# CITY OF ALBUQUERQUE

July 7, 2017

**Re: Drainage Ordinance (14-5-2-1) Violations for Erosion and Sediment Control and Trash**

Erosion Sediment Control Plan

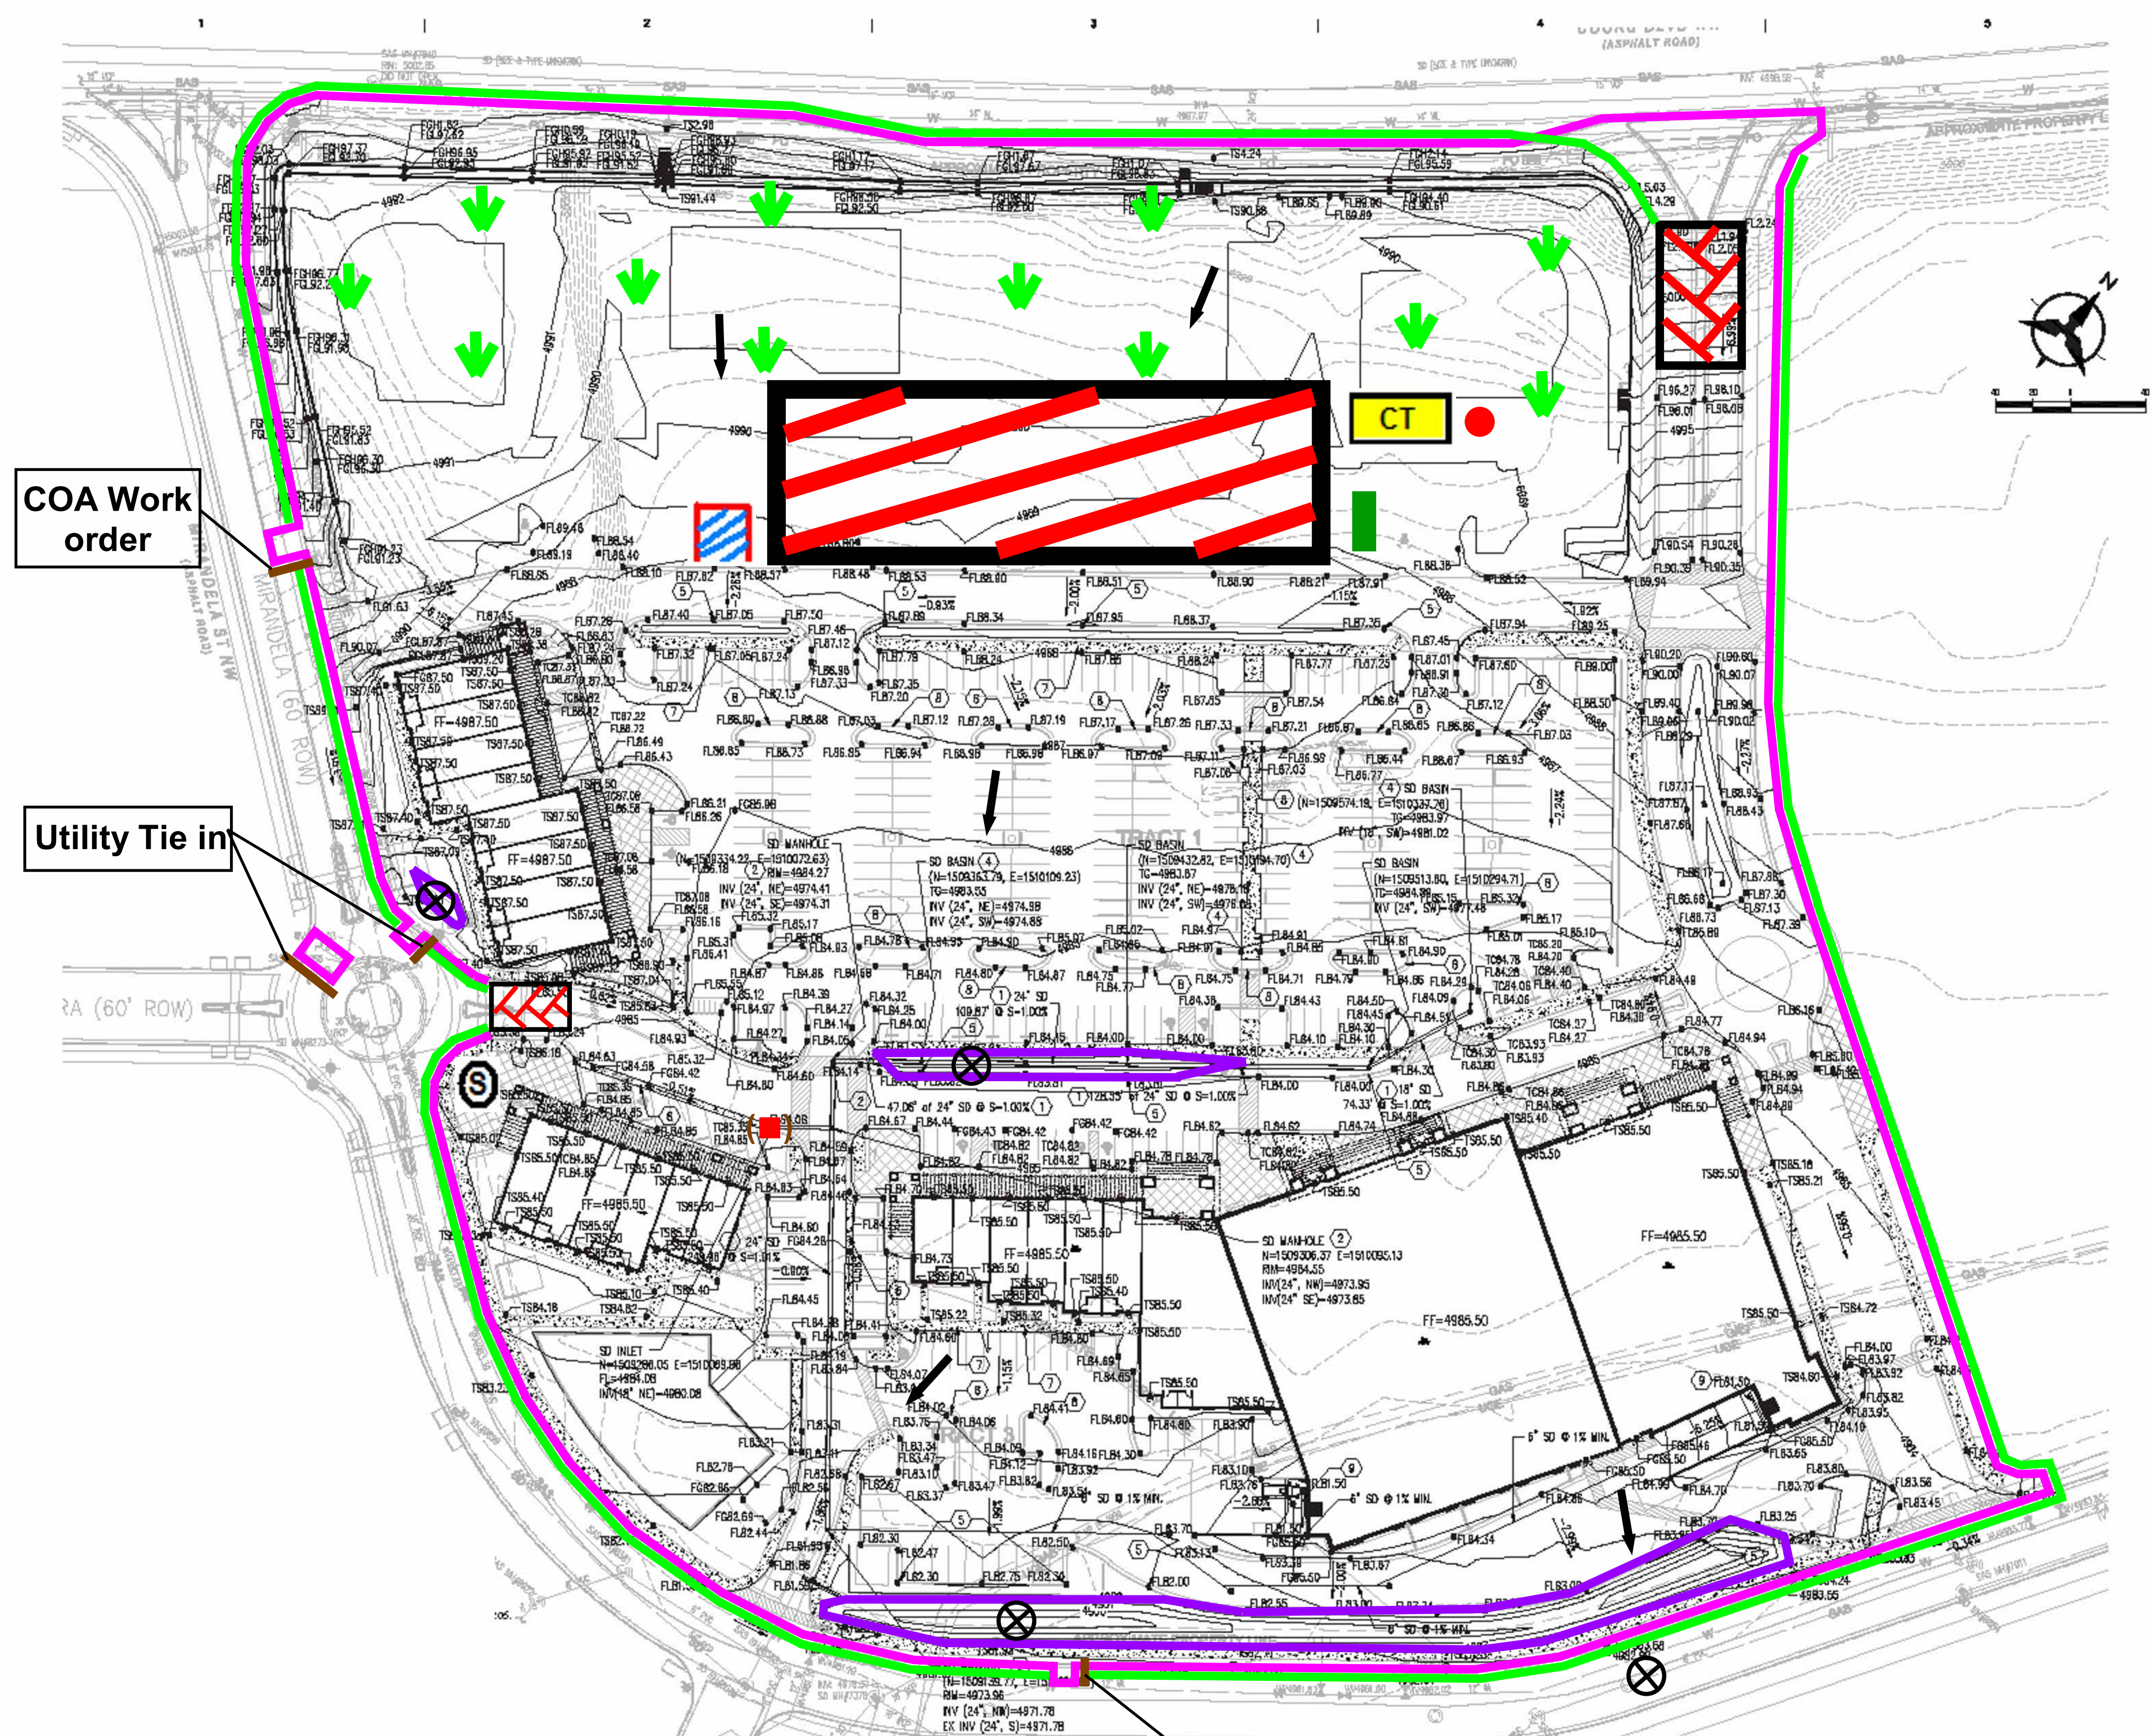
1. Trash and sediment in gutter of Mirandela St.
2. Inlet protection for both inlets in Mirandela St require maintenance.
3. Trash not in a trash receptacle and trash receptacle not observed onsite.
4. No BMP on south side of site; west of entrance.

1. Remove trash and sediment from project side of Mirandela St. from Coors Blvd to inlet near Montano Blvd.
2. Perform maintenance on inlet protection for both inlets in Mirandela St.
3. Bring in a trash receptacle(s).
4. Remove trash from entire site.
4. Install a sediment BMP along Mirandela St. on the south side of the site west of the entrance per approved Erosion and Sediment Control Plan.
